Charlotte Department of Transportation

Memorandum

Subject: Rezoning Petition 08-075: Located on the north side of East Woodlawn Road between Park Road and Halstead Drive

PROJECT NO. FFD-06020
 FILENAME: FFD06020-R21
 DESIGNED BY: CSS
 DRAWN BY: CSS
 SCALE: 1" = 40'
 DATE: 10-14-2008
 SHEET NO. **TD-1**

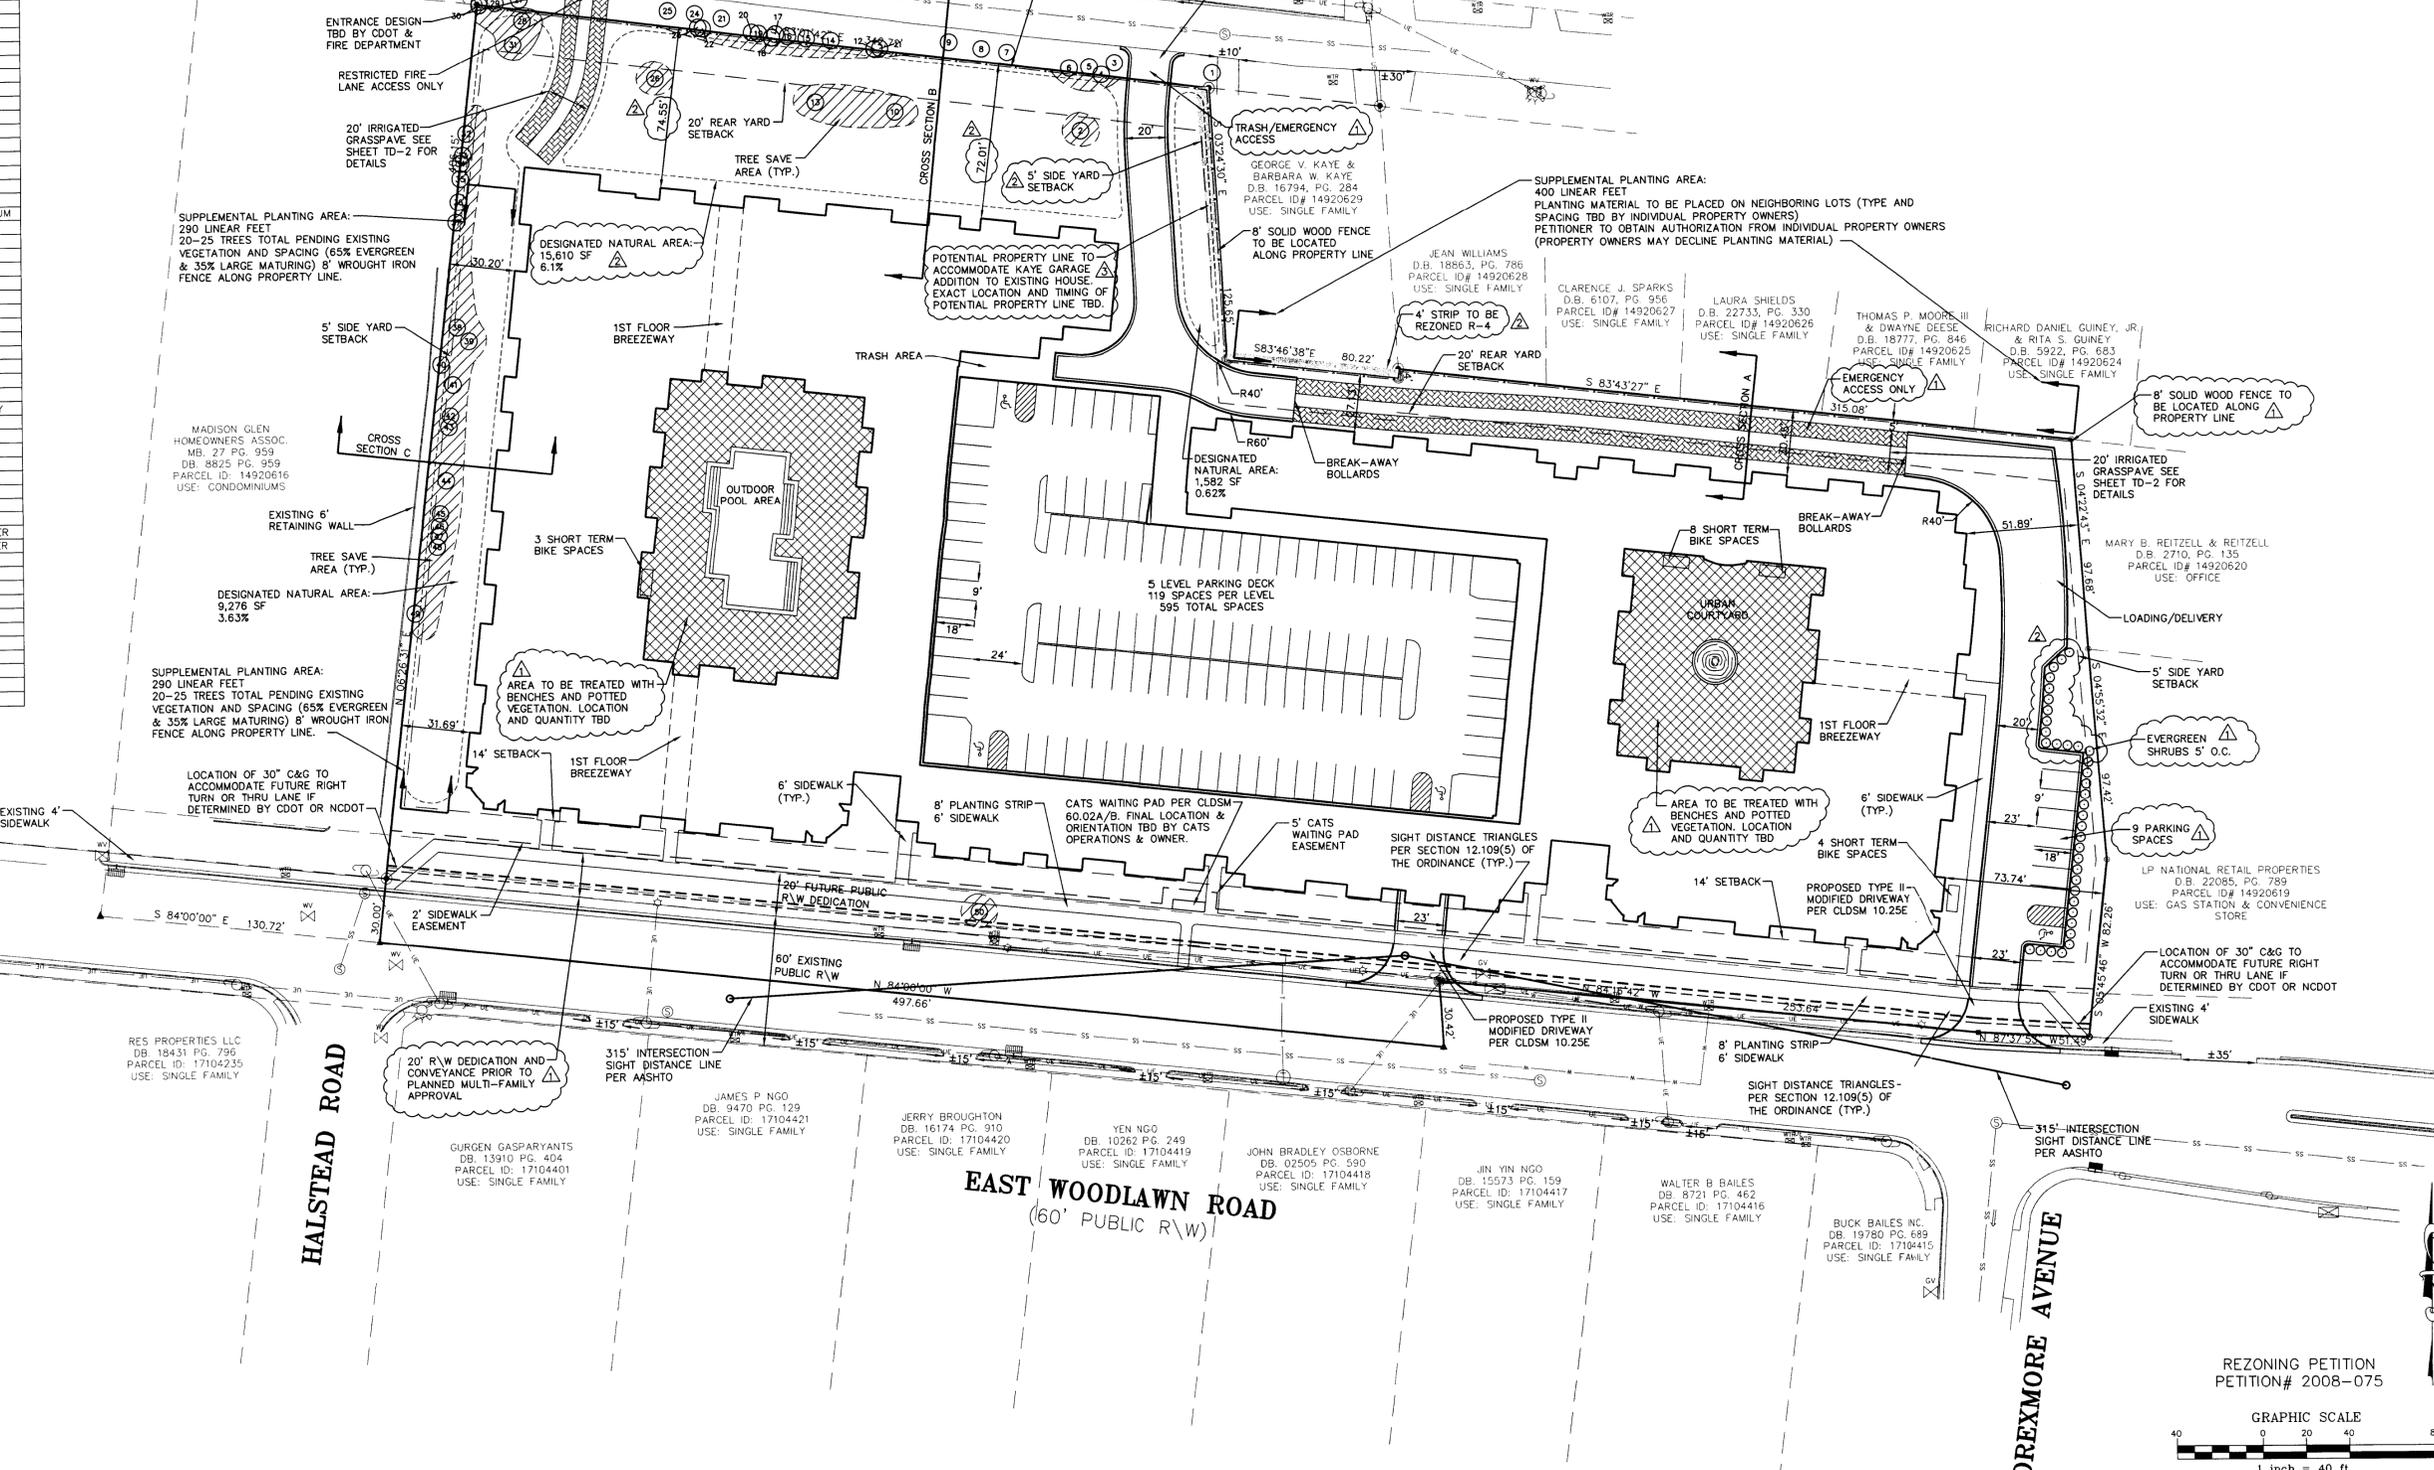
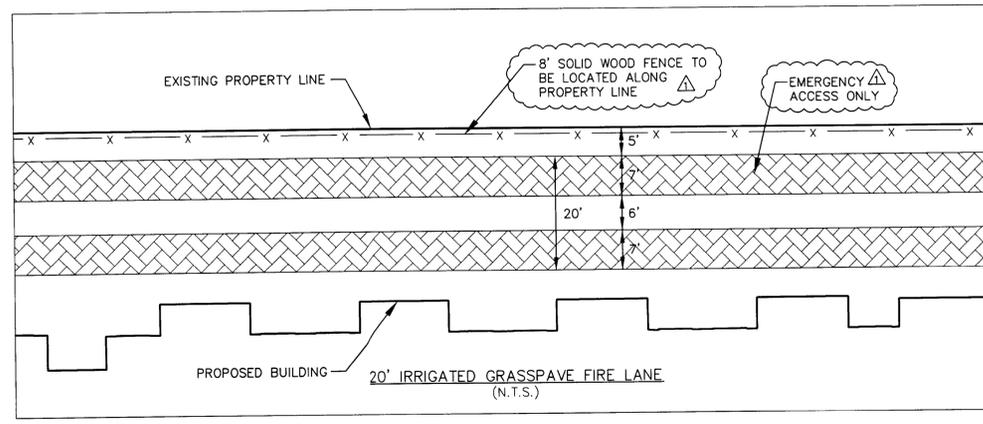
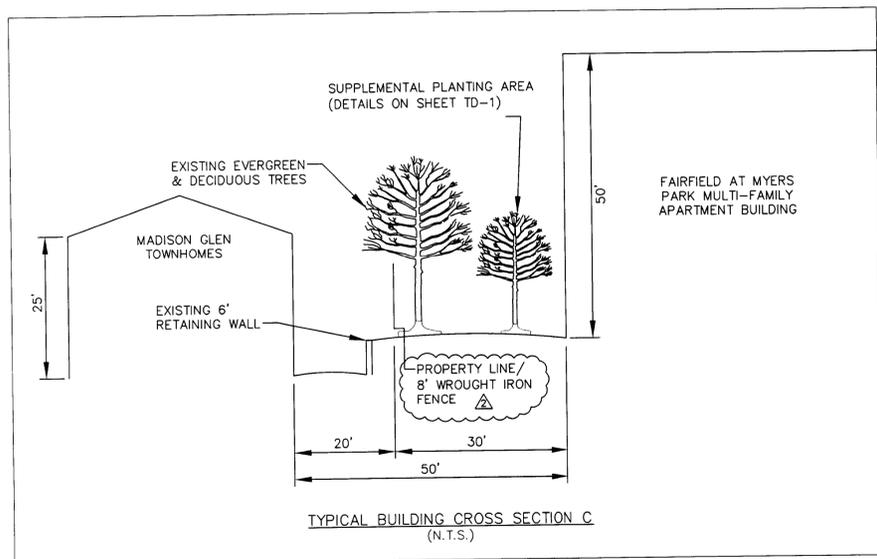
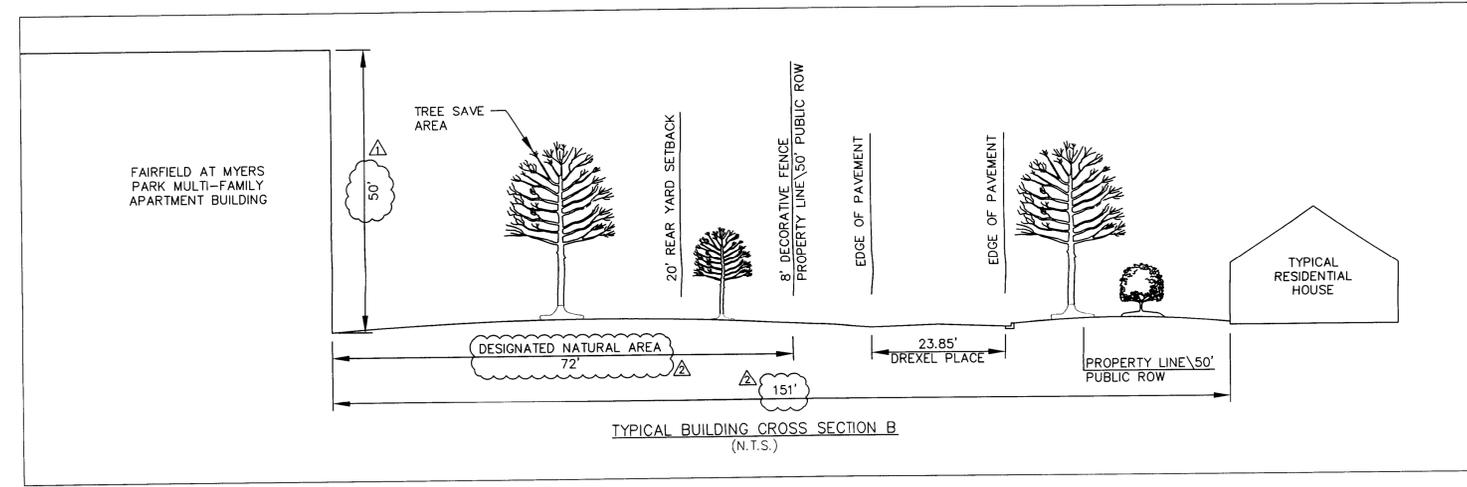
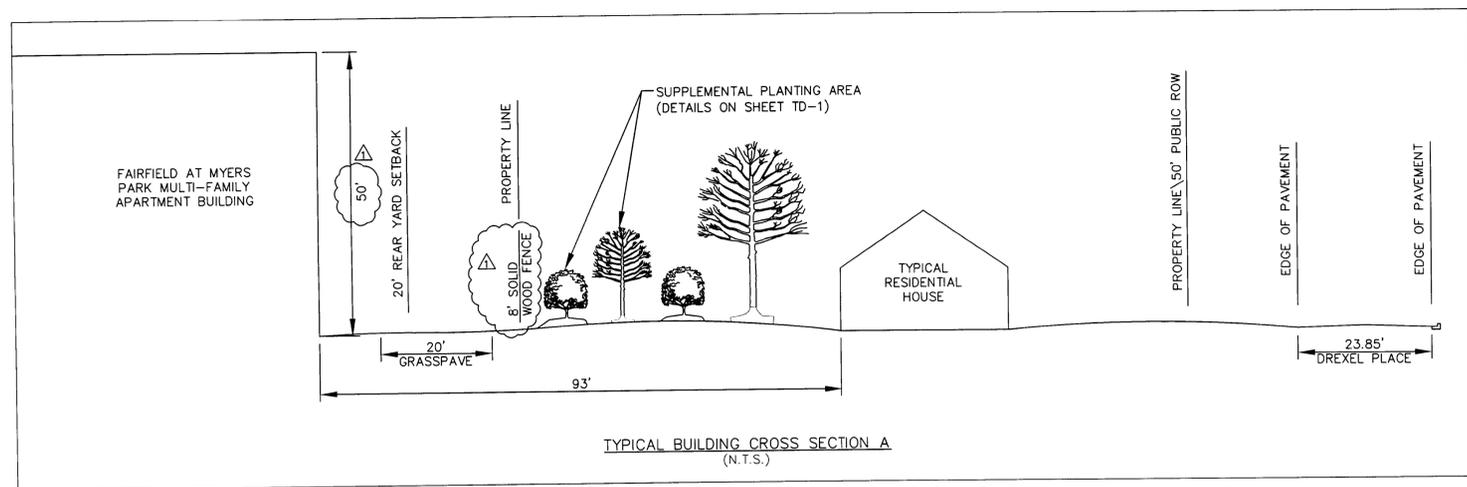
1. The subject site is located in a Center. The preferred block length in a Center is 500 feet and a maximum block length of 650 feet. The current block length on East Woodlawn Road between Park Road and Waterbury Drive exceeds 1,500 feet. This site has approximately 470 feet of frontage along East Woodlawn Road. Both existing and new developments need to be connected by streets, bikeways and pedestrian systems to reduce vehicle miles of travel (TAP Policy 2.9.4). For these reasons a new public street is needed in this location between East Woodlawn Road and Drexel Place. We recommend a curvilinear alignment along the eastern property line.

2. The new street described above is to be designed and constructed to the Local Residential Street-Wide (includes on-street parking) cross section in accordance with the adopted Urban Street Design Guidelines (USDG). This cross section includes 10-foot travel lanes, 7-foot parking lanes, 8-foot planting strips, and 6-foot sidewalks. The developer may construct parking, planting strip and sidewalk on only the side abutting their development; the eastern edge of the new street may be left as a travel lane against curb and gutter.

3. Parking deck access needs be located along the required new street and not on East Woodlawn Road as currently shown.
4. New curb/gutter, planting strip (8'), and sidewalk (5') along Drexel Place are required to be constructed by the developer. The sidewalk can meander to preserve/minimize the impact to existing trees and the existing 6-foot tall wood fence, keeping at least 6 feet away from the new curb/gutter. A waiver of these items may be requested through subsequent building permit phases, but not through the zoning process. The note on the plan requesting a waiver of these items needs to be removed.

East Woodlawn Road is a major thoroughfare requiring a minimum of 100 feet of right-of-way. The developer/petitioner should convey right-of-way in fee simple title to meet this requirement, measuring 50 feet from the centerline of the roadway.

Adequate sight triangles must be reserved at the existing/proposed street entrance(s). Two 35-foot x 35-foot and two 10-foot x 70-foot sight triangles are required for all entrance(s) to meet requirements. All proposed trees, berms, walls, fences, and/or identification signs must not interfere with sight distance at the entrance(s). Such items should be identified on the site plan.
